STATE OF NORTH CAROLINA
DEPARTMENT OF TRANSPORTATION

Addendum No. 1

RE: Contract # C204328
WBS # 2019CPT.08.08.10631, Etc.
STATE FUNDED

4 SECTIONS OF US-15/501, 2 SECTIONS OF NC-22 AND NC-5, 1
SECTION OF NC-705, AND 6 SECTIONS OF SECONDARY ROADS

DETAILS OF PATCHING EXISTING PAVEMENT PRIOR TO RESURFACING

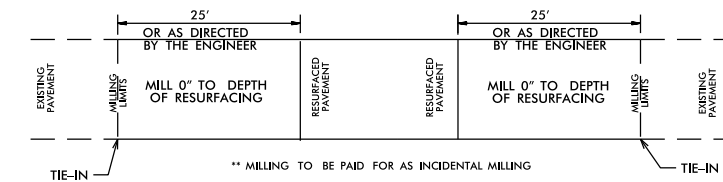
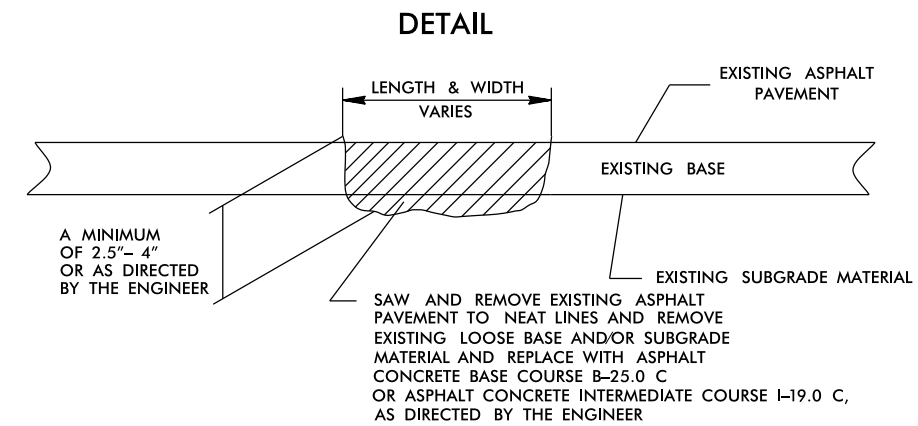
| Sheet No. | Revisions |
|-----------|---|
| 7 | Revised notes under "DETAIL OF PATCHING EXISTING PAVEMENT PRIOR TO RESURFACING" |
